**Consultation Response from KC,
Highways Development Management**

2020/94203 Clough House, 236, Leeds Road, Birstall, Batley, WF17 0HW

Outline application for demolition of dwelling and associated outbuildings and the erection of 30 dwellings

**Date
Responded:26/01/2020**

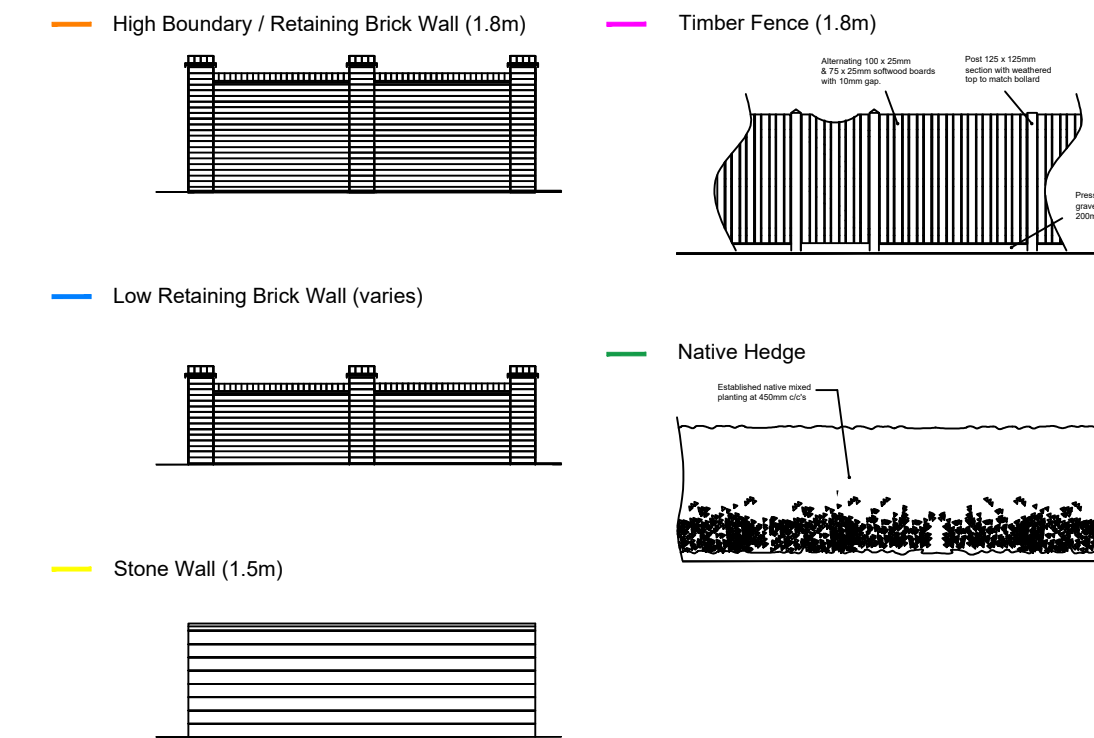
1, A single point of access into the site from Moat Hill Farm Drive should be considered. In any case a dropped vehicular crossing off a classified road such as Leeds Road serving an adoptable access road to 7 dwellings is unacceptable.

2, No Levels are provided. These are needed to determine whether a shared surface carriageway is appropriate on this site. The desirable maximum carriageway longitudinal section gradient on all adoptable shared surface carriageways is 1 in 20 (5%). If this is not achievable then the specific circumstances should be discussed with the Council to address potential mobility and safety implications. A gradient no steeper than 1 in 10 (10%) is preferred.

The gradient of a non-priority route on the approach to a junction should be a gradient of 1 in 40 (2.5%) for the initial 10 metre length with an absolute maximum of 1 in 25 (4%).

3, Swept paths should be provided which demonstrate that an 11.85m refuse vehicle can enter and exit the site and turn within the site. All schemes must incorporate reasonable tolerances and safety margins. A good starting point is to allow 0.5m clearance to kerbing or vertical obstructions on each side of the swept path. Designs should therefore, where possible, aim to cater for vehicles larger than the above minimum standards

4, Bin collection points should be shown to be provided to all dwellings to enable bins to be presented on collection day without either obstructing the highway or proposed driveways.

6, The ramped access from Moat Hill Farm Drive is not needed given that it is proposed to extend into a traditional estate road.
